Sheringham Shoal and Dudgeon Offshore Wind Farm Extension Projects

Final Statement of Common Ground with National Highways (Revision E)

Document Reference: 12.22

DRAWING No.	REVISION
PB8164-RHD-ZZ-XX-GA-R-0006	P02

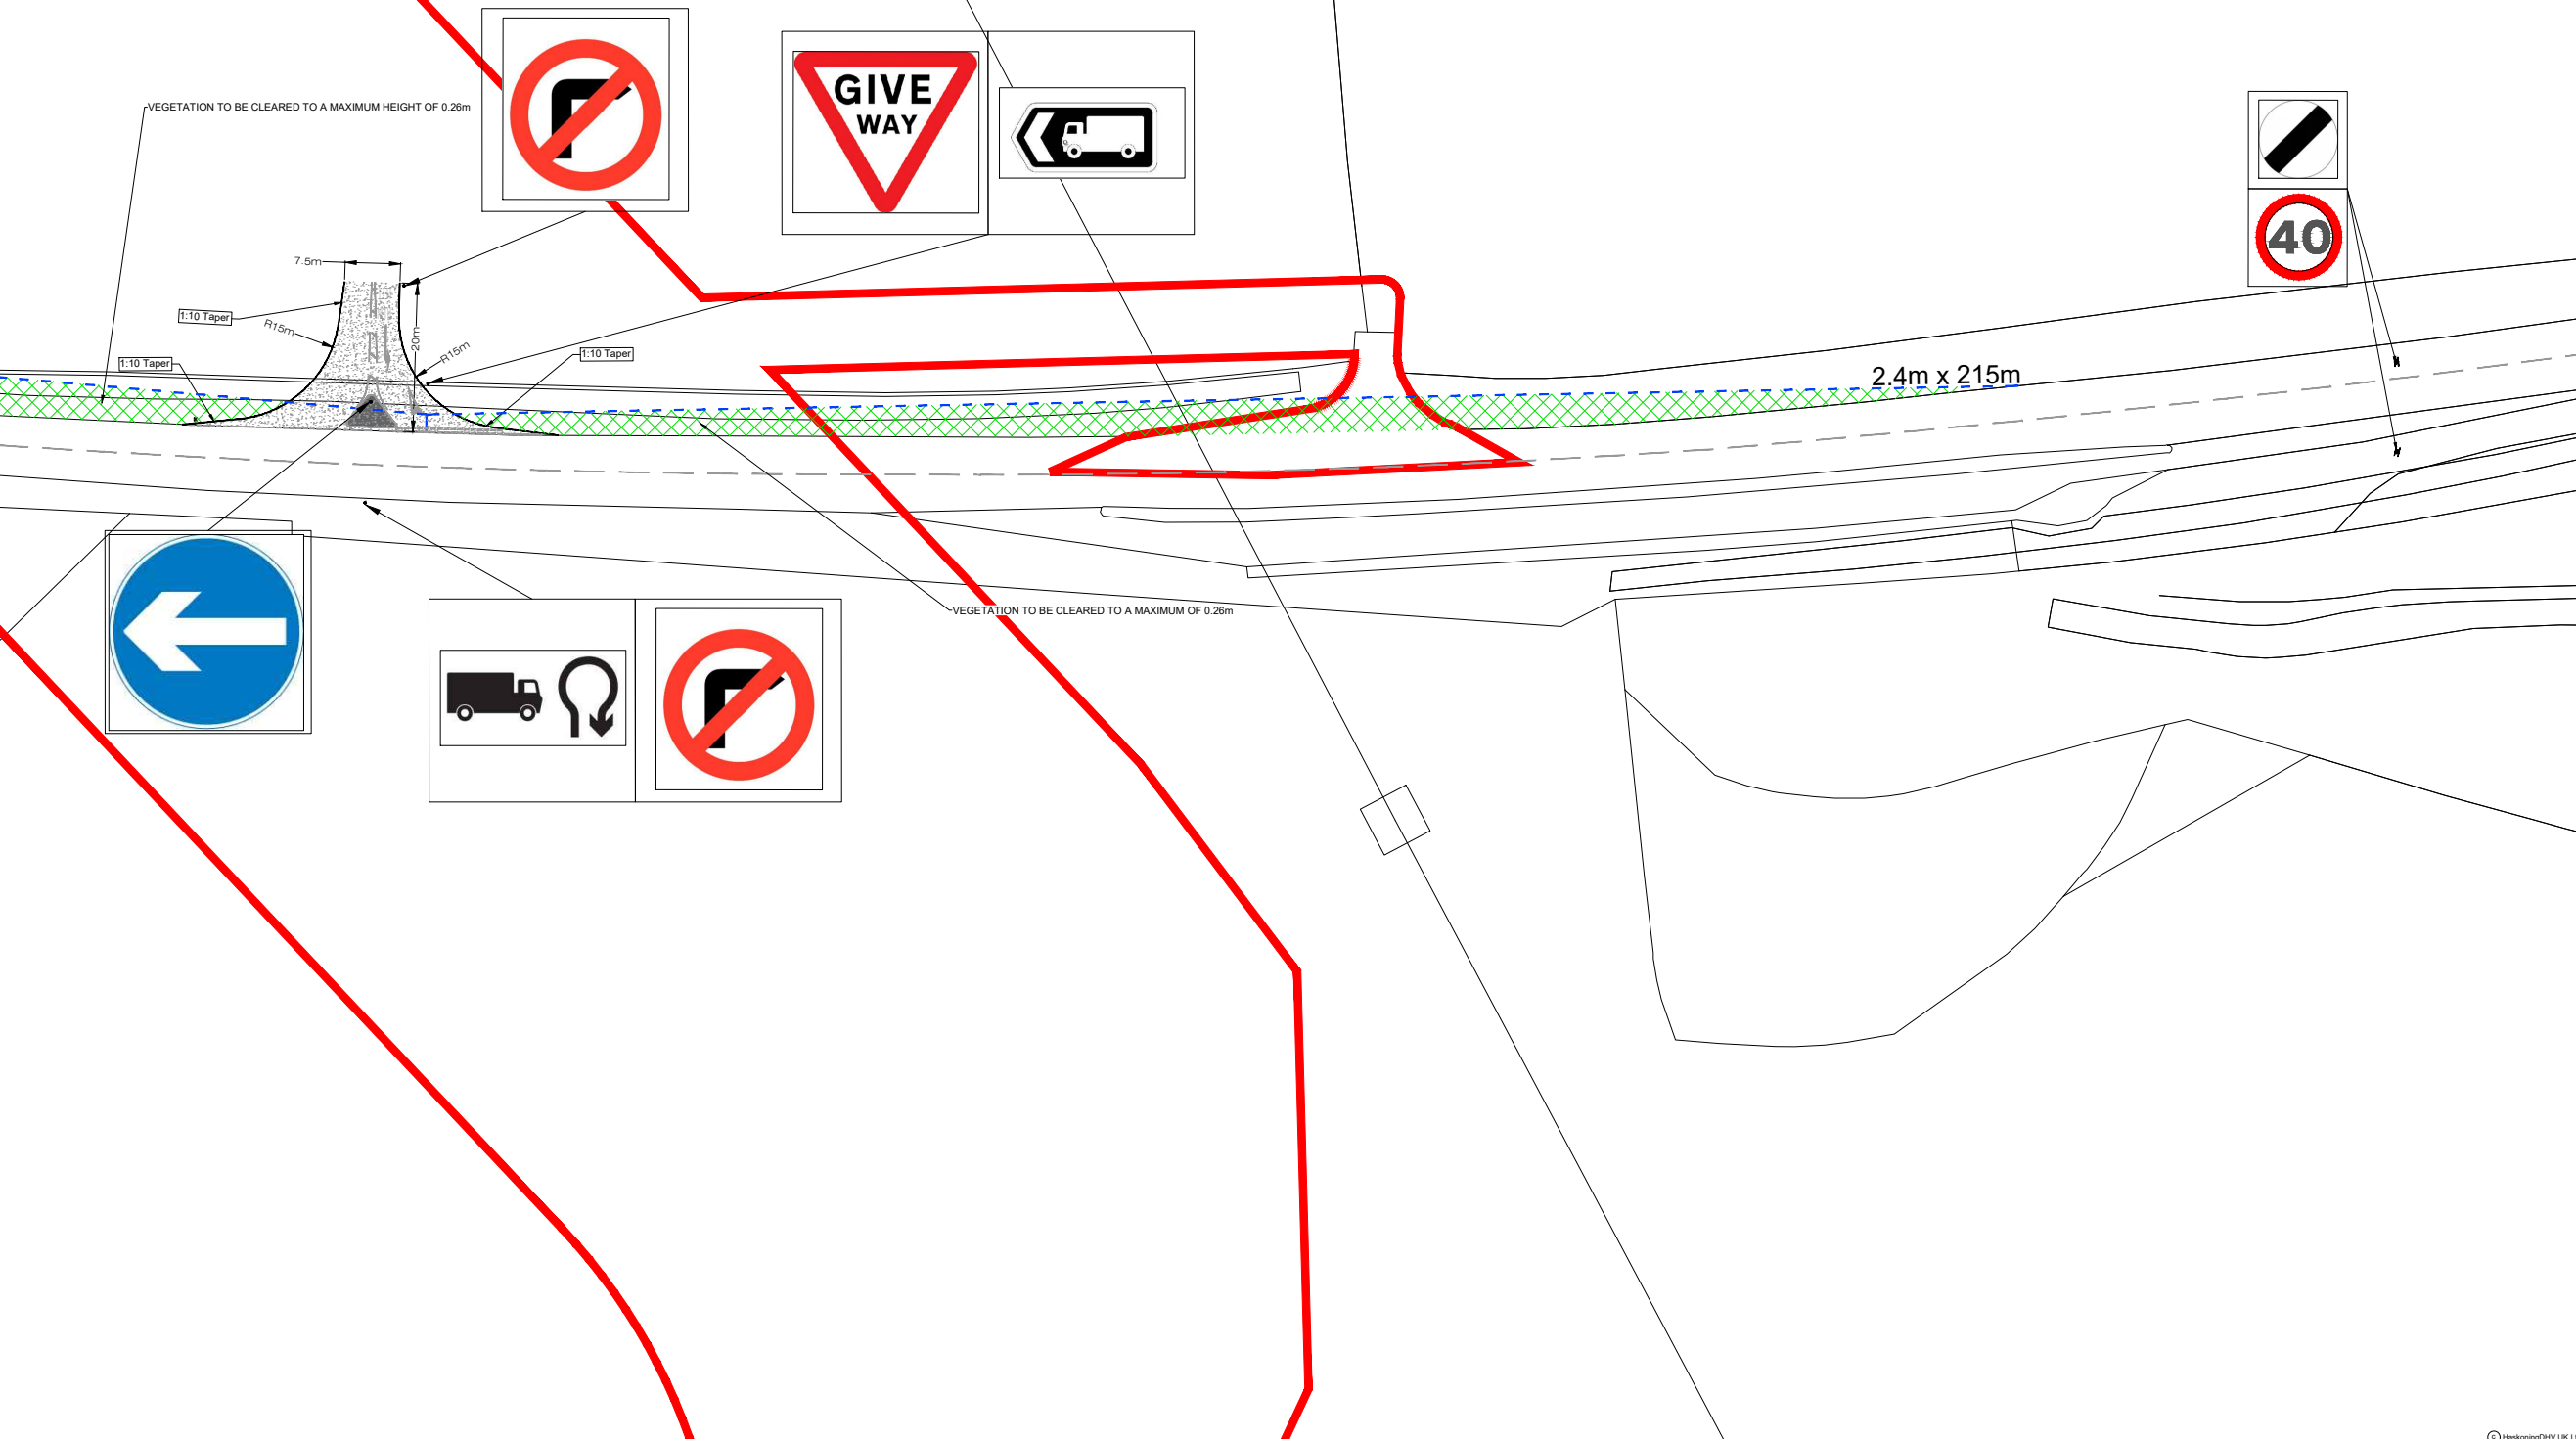
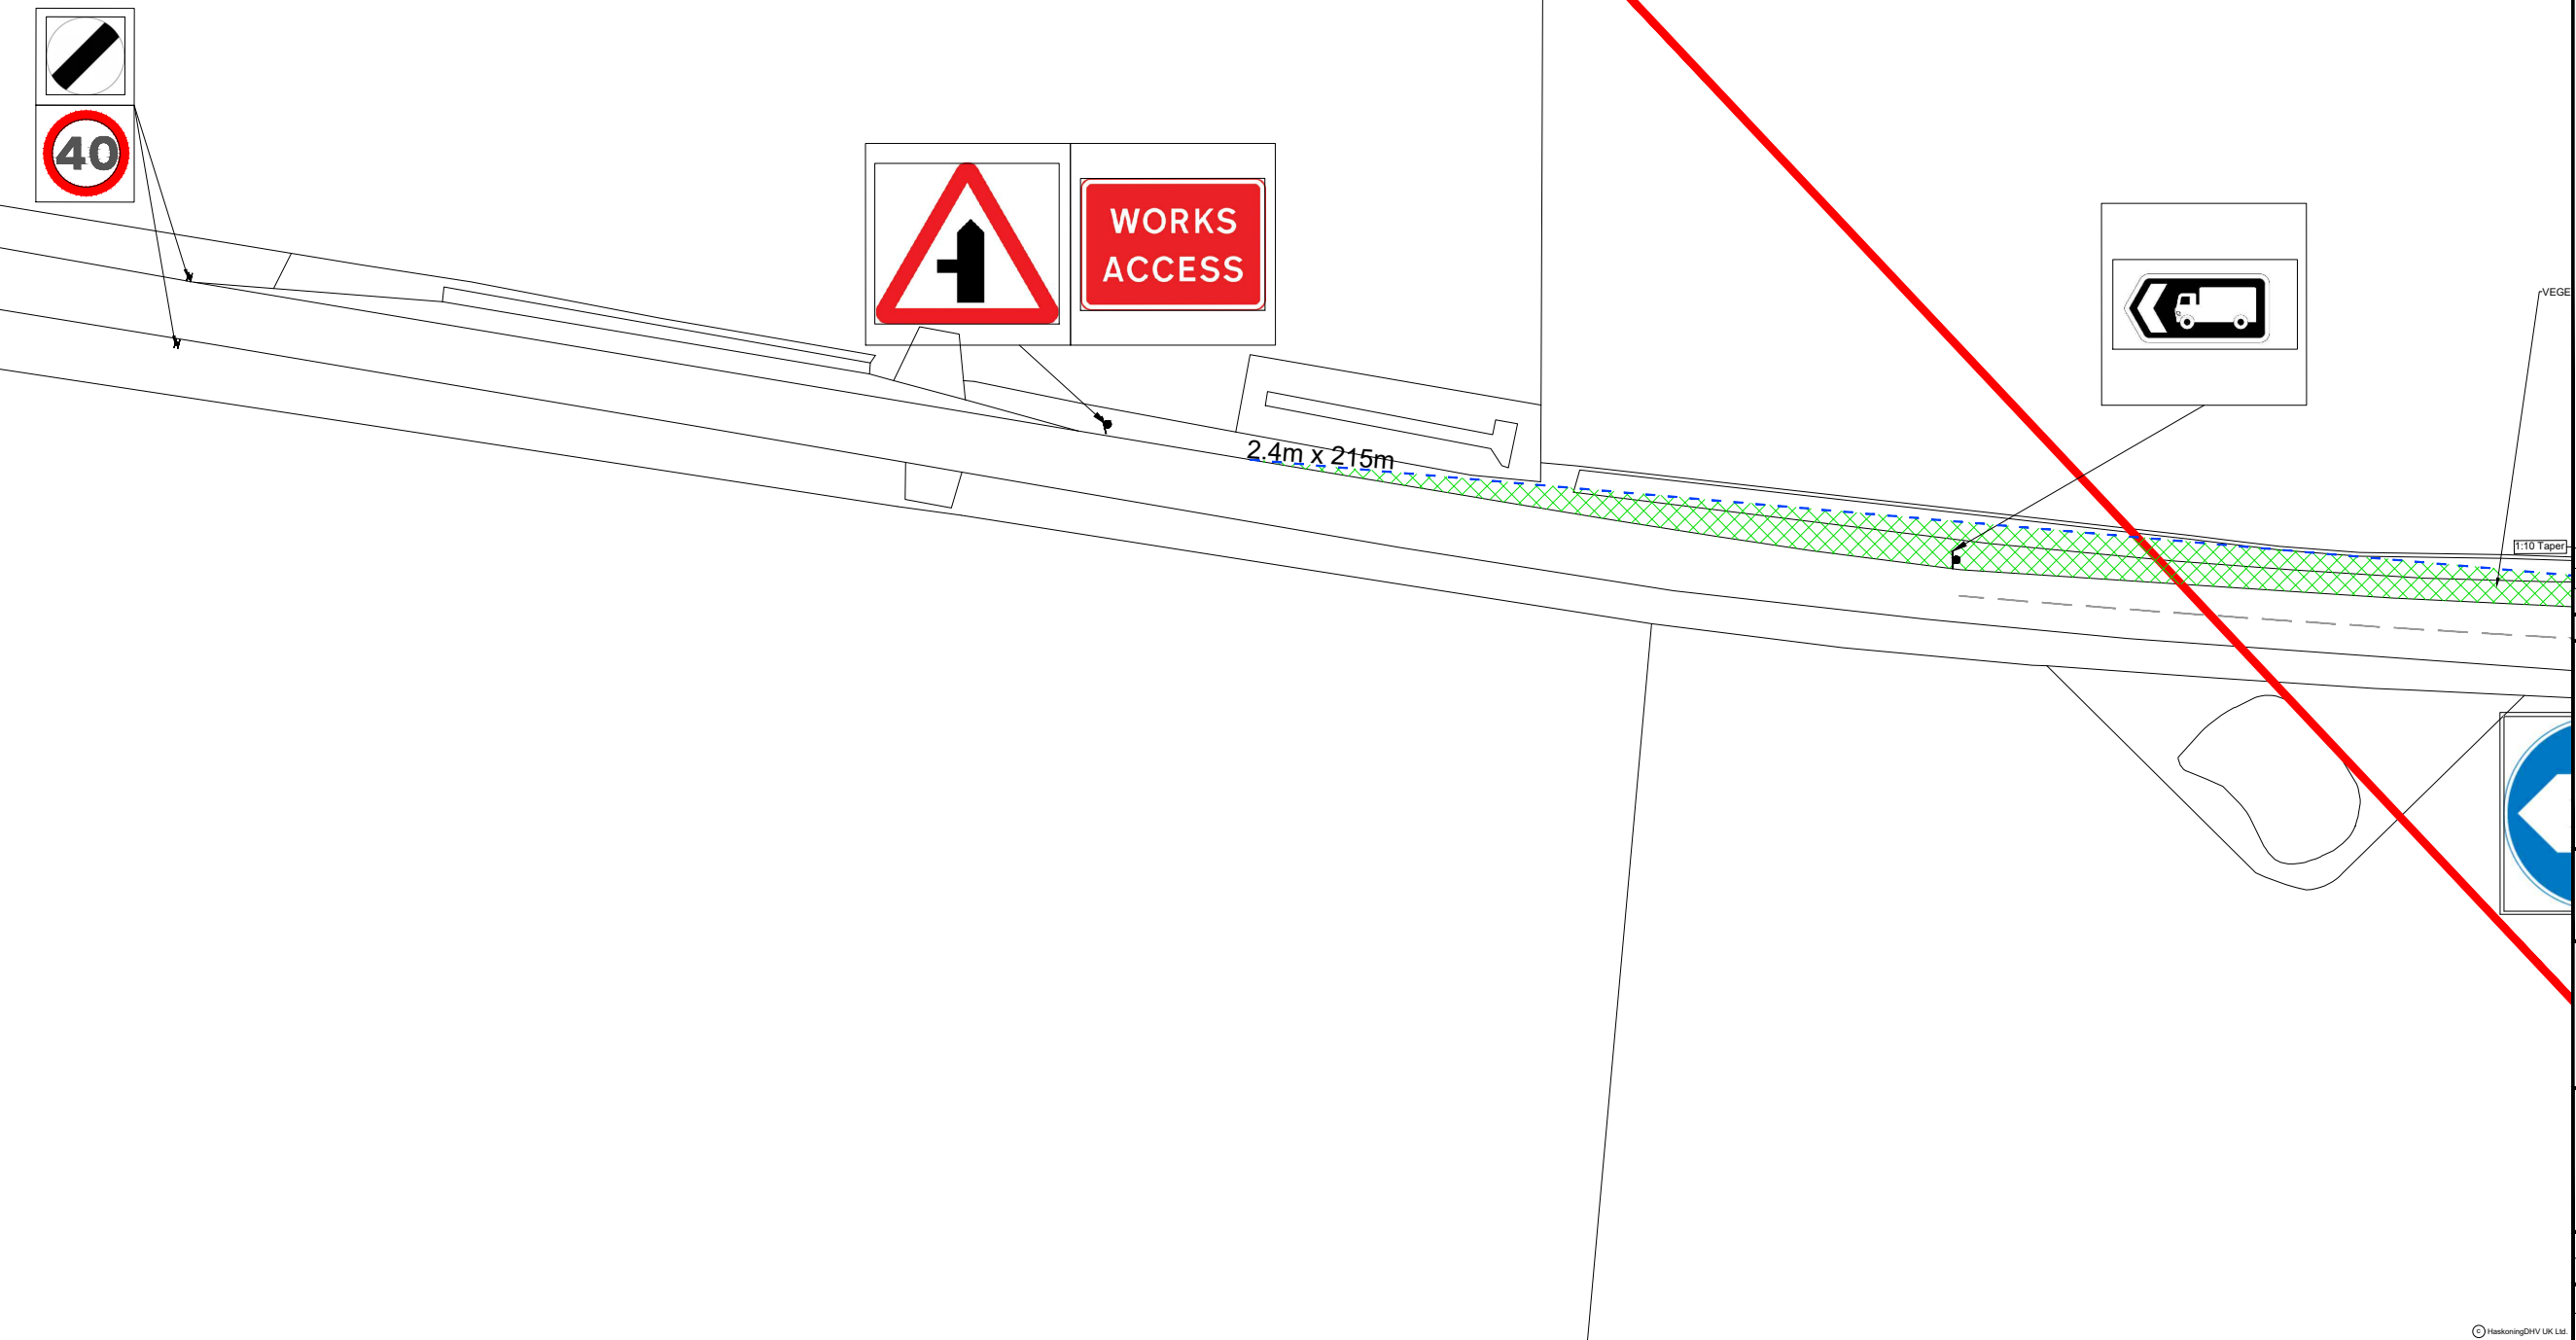
23	The outline design for an access off the A47 is appropriate, as presented in Annex 30 of the Transport Assessment [APP-268 and APP-269]	National Highways agree that the outline design for an access off the A47 (ACC47) is appropriate subject to Stage 1 and 2 Road Safety Audits being carried out post consent. Please note that this access is only usable until the A47 Tuddenham scheme starts construction, or if the A47 Scheme does not go ahead.	<i>Agreed</i>
EIA – Cumulative Impact Assessment (CIA) Conclusions			
24	Cumulative impacts assessment with other windfarms, as presented in Section 24.7 of ES Chapter 24 Traffic and Transport [APP-110], is appropriate based on currently available information and proposed mitigation, impacts are not significant in EIA terms.	National Highways agree that the cumulative impacts assessment with other windfarms, in relation to effects on traffic along the SRN, as presented in Section 24.7 of ES Chapter 24 Traffic and Transport [APP-110], is appropriate based on currently available information and proposed mitigation, impacts are not significant in EIA terms.	<i>Agreed</i>

29	The access concept design for access ACC47 is appropriate and that detailed access designs can be developed and agreed with National Highways prior to the start of construction, secured under Requirement 16 of the draft DCO [AS-009].	National Highways agree that the access concept design for access ACC47 is appropriate, subject to Stage 1 and 2 Road Safety Audits to be carried out post consent, and that detailed designs can be developed and agreed with National Highways	<i>Agreed</i>
